Development Control
Ribbles Valley Borough Council

Your ref: 2018/1105
Our ref:
Date: 27/12/2018

Re: Planning Application 18/1105

Address: Higher College Farm Lower Road Longridge PR3 2YY

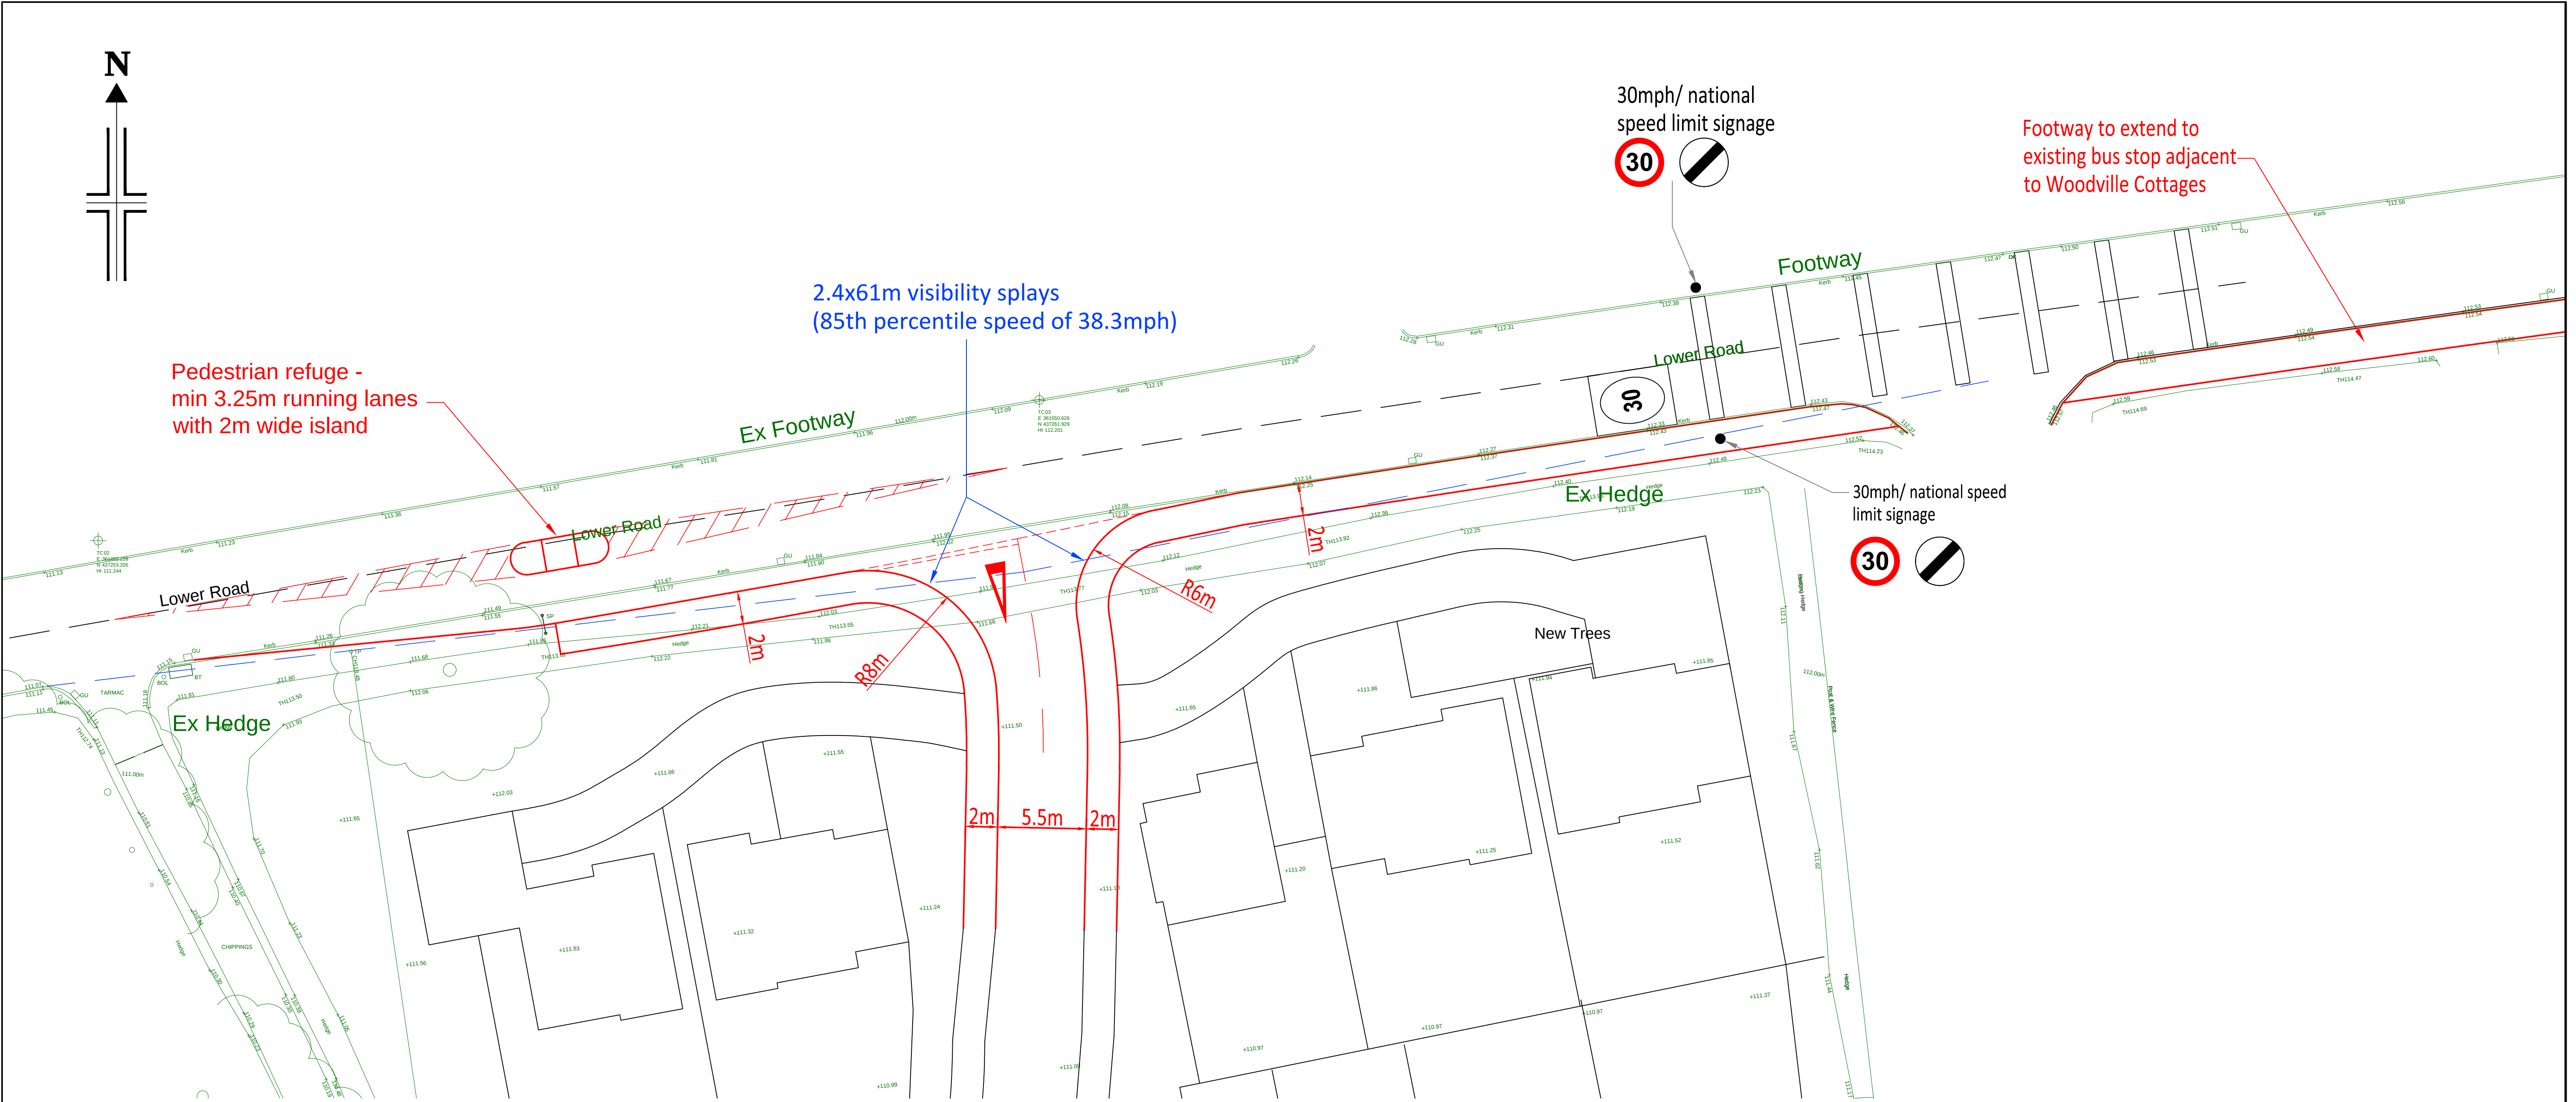
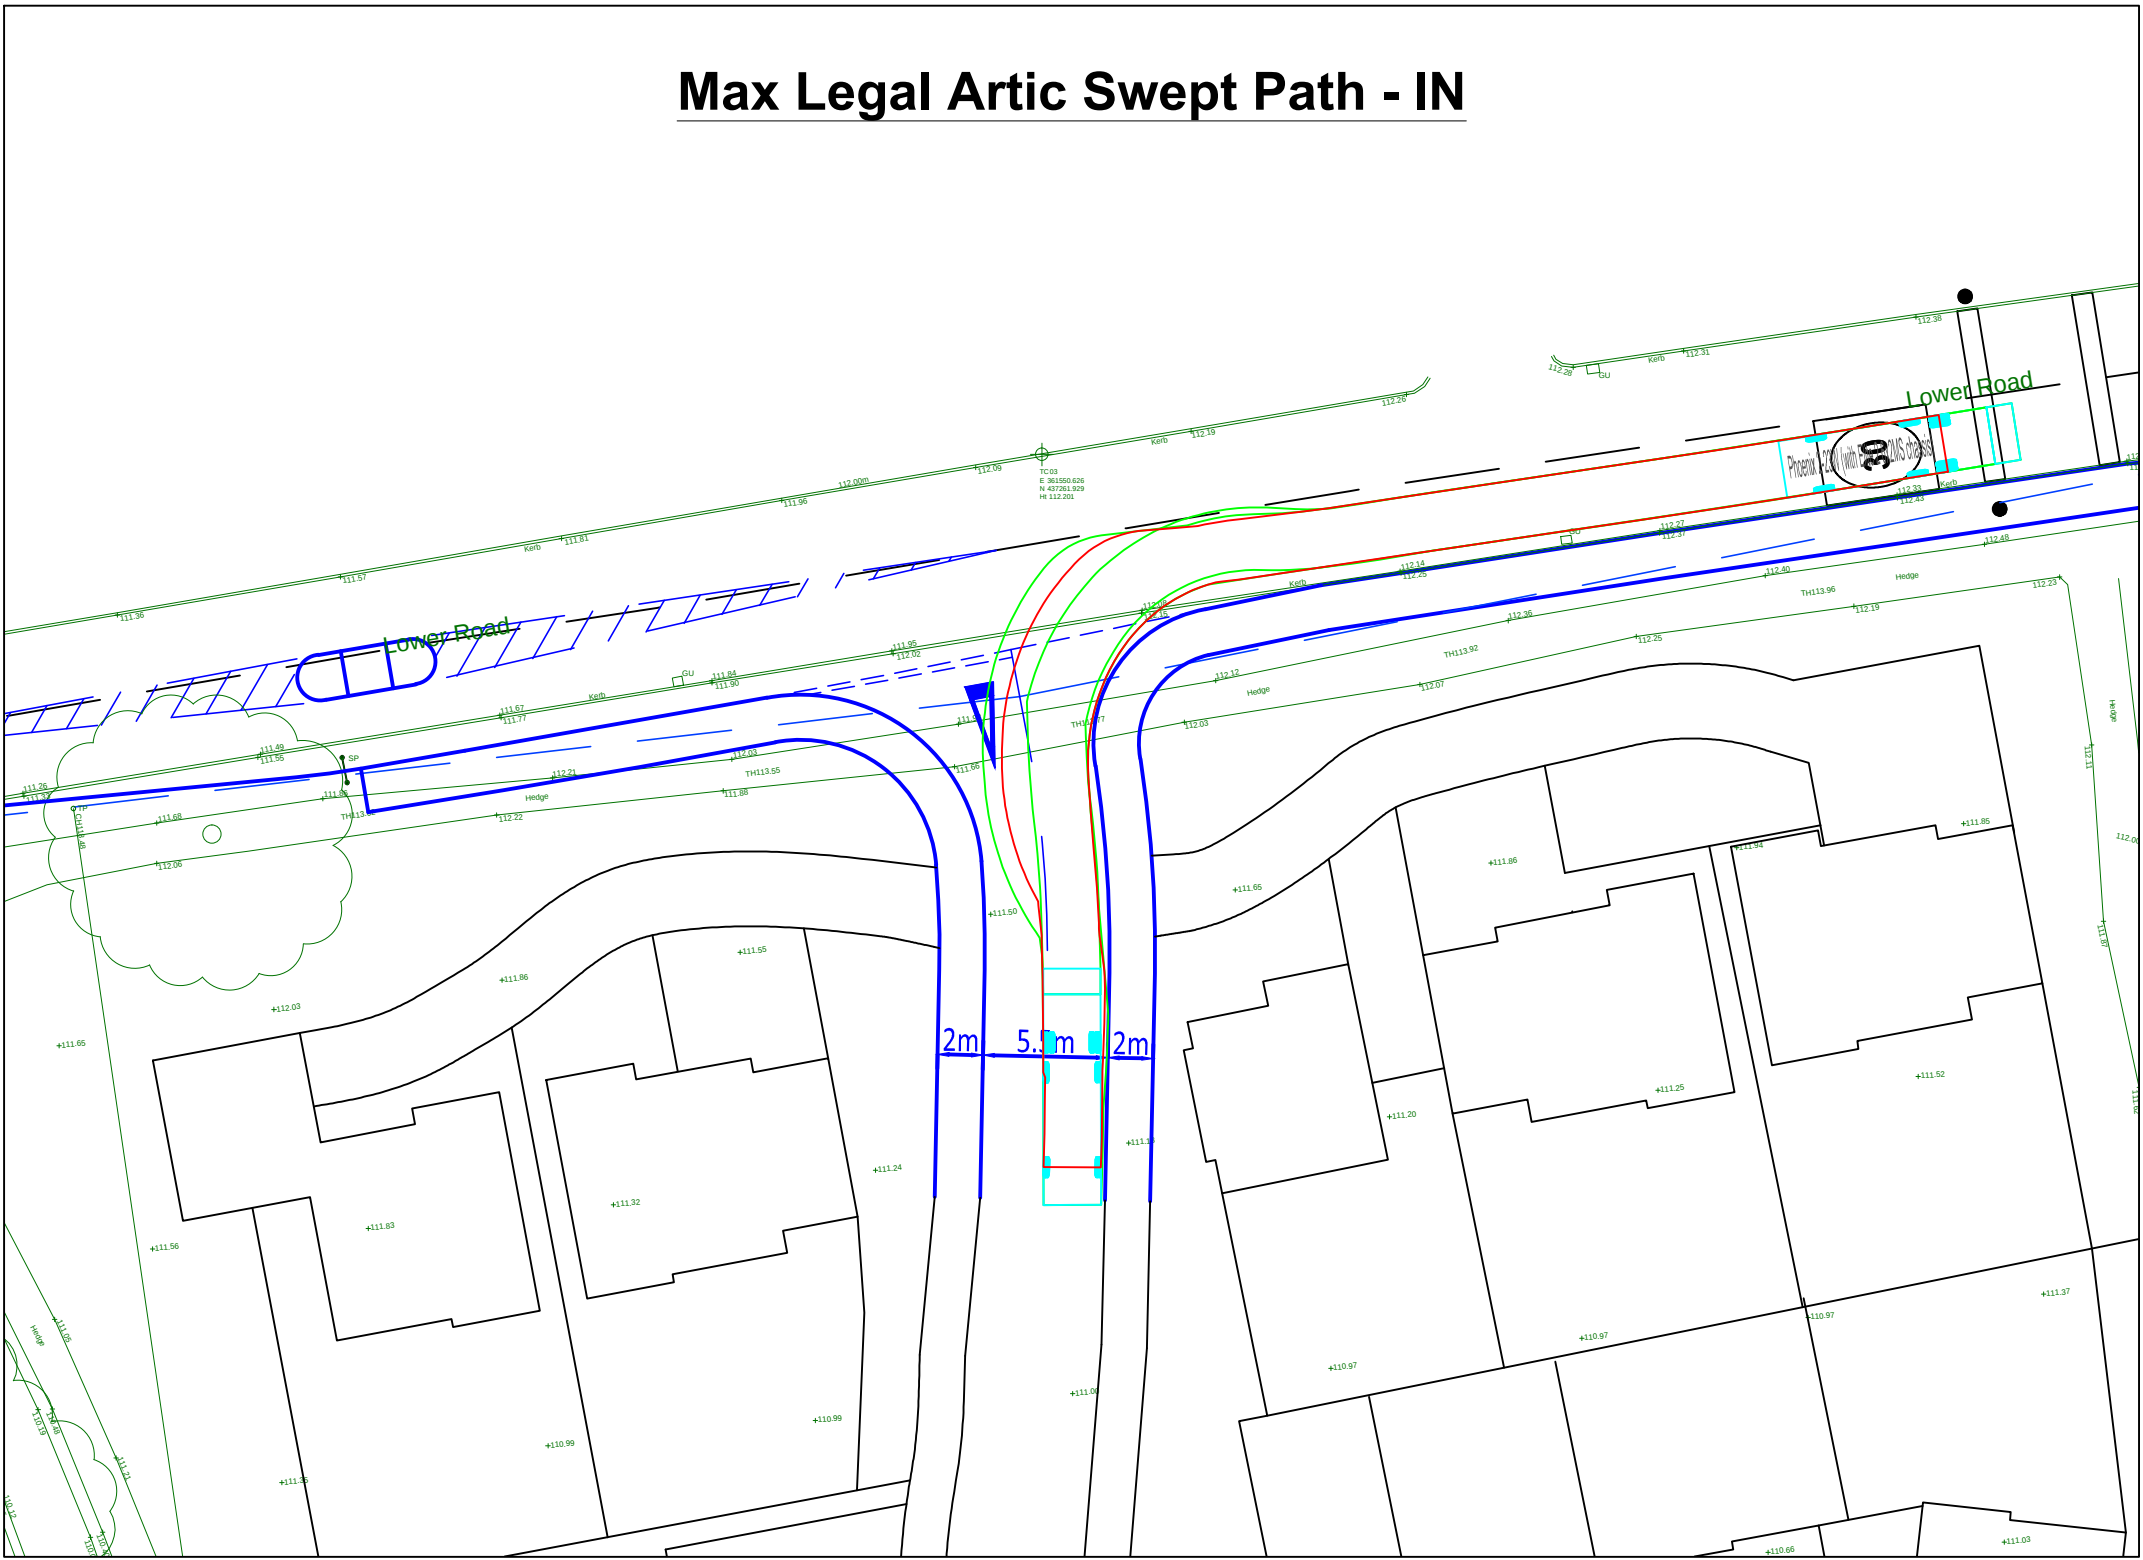
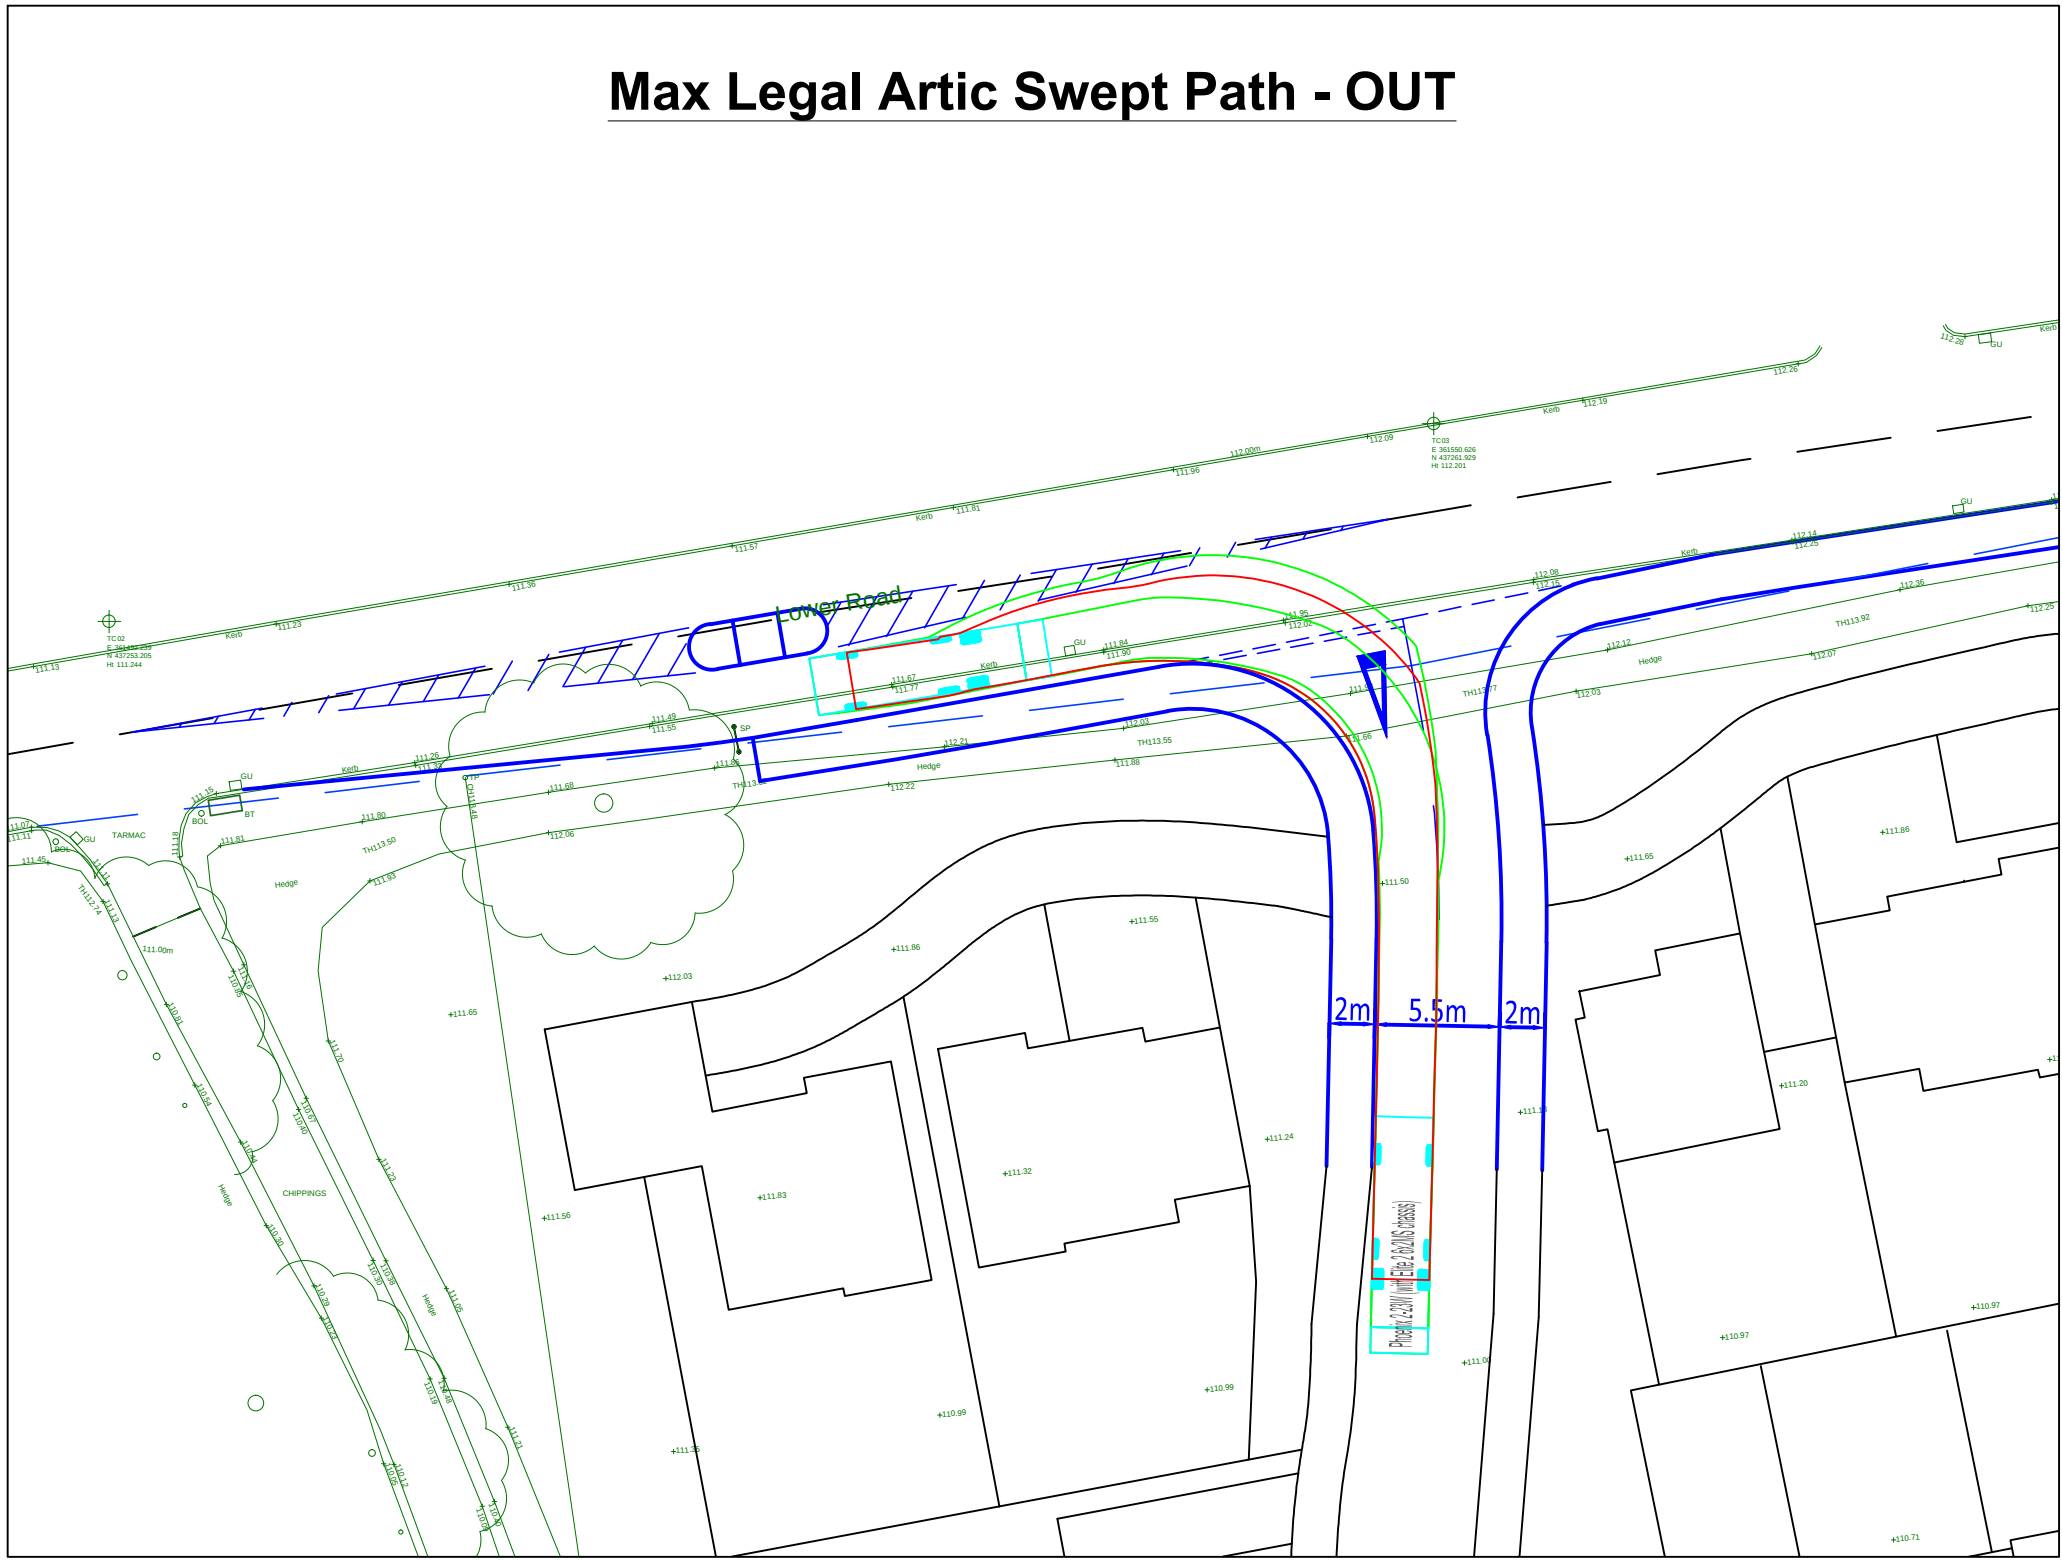
There are however a number of concerns regarding the self build elements of the development which would require some further information and some conditions relating to the timing of the works required to form the new access and associated infrastructure. It is noted that the plans showing the expected entrance do not show the bus stop approximately opposite the new access that is to be formed. It is also expected that the new junction and access road are to be substantially completed prior to the commencement of any building works, as it is not expected that the plots will be sold and developed in a similar manner to a conventional housing development.

In order to ensure that the estate road and its junction are satisfactorily completed we would look for the new junction to be completed prior to any construction works being carried out on the first plot being sold and the entire estate road being complete to base level within 6 months of the plots commencement of construction works, this shall include the provision of a footway for the full perimeter of the turning head.

In order to fully support the application we would look for a plan showing the swept path analysis for a large articulated heavy goods vehicle at the junction of Lower Road B6243 and Preston Road B6245. The vehicle shall be shown completing all the expected turning movements accounting for the new build out.

4. The new estate road for the approved development shall be constructed in accordance with the Lancashire County Council Specification for Construction of Estate Roads to at least base course level up to the turning head, the turning head shall include a constructed footway around the turning head. **Reasons:** To ensure that satisfactory access is provided to the site before the development hereby permitted becomes operative.

5. No part of the development hereby approved shall commence until a scheme for the construction of the site access and the off-site works of highway improvement has been submitted to, approved by, the Local Planning Authority in consultation with the Highway Authority as part of a section 278 agreement, under the Highways Act 1980 and these works shall be completed prior to the commencement of any building works. **Reasons:** In order to satisfy the Local Planning and Highway Authorities that the final details of the highway scheme/works are acceptable before work commences on site and to enable all construction traffic to enter and leave the premises in a safe manner without causing a hazard to other road users.
